23 August 2022

**Western Coal Services (SSD 5579) – MOD 4 RTS**

On 14 March 2022, Springvale received, via the Department of Planning and Environment (**DPE**), feedback from the DPE-Water (as well as other Government Departments) relating to the MOD 4 proposal, requesting further information. On the 24 June 2022, Springvale provided a Response to Submissions Report addressing those requests for further information. On 29 July 2022, further information and clarification regarding the MOD 4 proposal was requested by DPE-Water (Your ref: OUT22/9260). The purpose of this letter is to address those outstanding matters raised by DPE-Water. They are addressed herein under the headings provided.

Western Coal Services Project
Figure 2

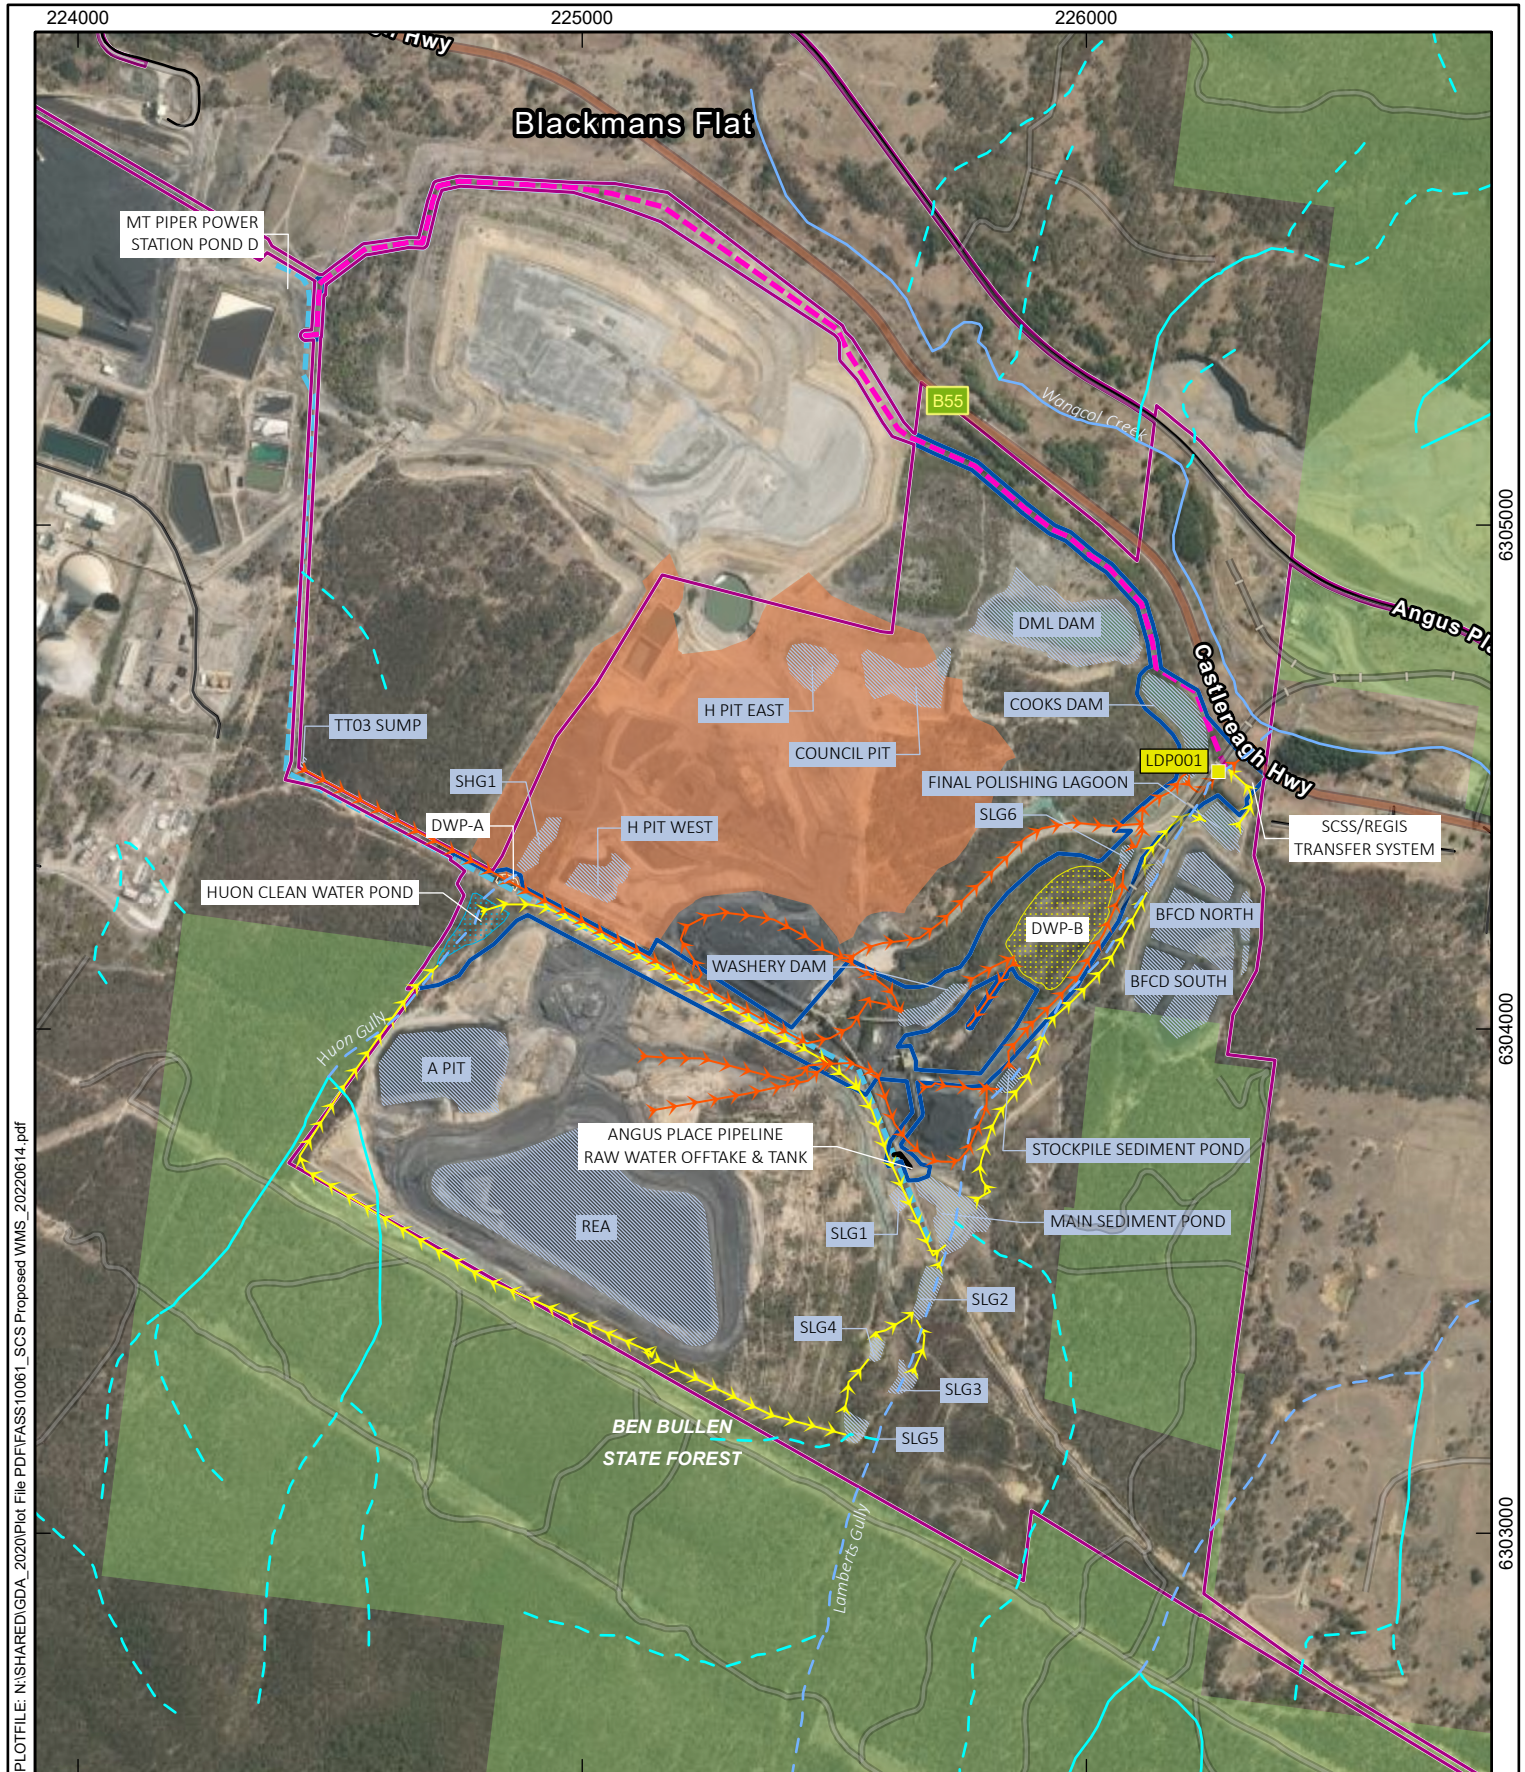
**Information Request** – that the proponent provides further clarification on the management of clean and dirty water separation from the Huon Clean Water Pond into Lamberts Gully. This is to assist in addressing a query originally raised on review of the EIS.

If the water diverted from the Huon Clean Water Pond is clean, it is recommended it be diverted directly into a clean section of Lamberts Gully. Alternatively, if all water captured in the Main Sediment Basin is clean, further clarification is required.

We can confirm that water captured in the Main Sediment Basin is clean. Figures 3.1 and 3.2 (and Figure 5.1 of Appendix A) within the Modification Report presented (amongst other things) the existing surface water management system at the SCSS. Figure 4.2 (and Figure 5.3 of Appendix A) within the Modification Report presented (amongst other things) the proposed surface water management system. The five figures were drawn to show that dirty water is captured within and cascades through SLG5, SLG4, SLG3, SLG2 and then into the Main Sediment Dam. Furthermore, the five figures showed that dirty water flows around the toe of the rehabilitated area to the east of the REA, into SLG1 and then into Main Sediment Dam.

The figures described above are in error. The existing water management system should show clean water captured within and cascading through SLG5, SLG4, SLG3, SLG2 and then into the Main Sediment Dam and clean water flowing in a south easterly direction around the toe of the rehabilitated area to the east of the REA, into SLG1 and then into Main Sediment Dam. In summary, only clean water reports to the Main Sediment Dam. Centennial presented this correction in its Response to Submissions Report, however, further clarification was requested by DPE-Water. To that end, Centennial presented the above mentioned correction and provided a detailed explanation to better clarify the errors during its meeting with DPE-Water and the DPE on 18 August 2022. The pertinent slides presented at this meeting are provided in **Attachment 1**. The corrected surface water management figure is presented in **Attachment 2**.
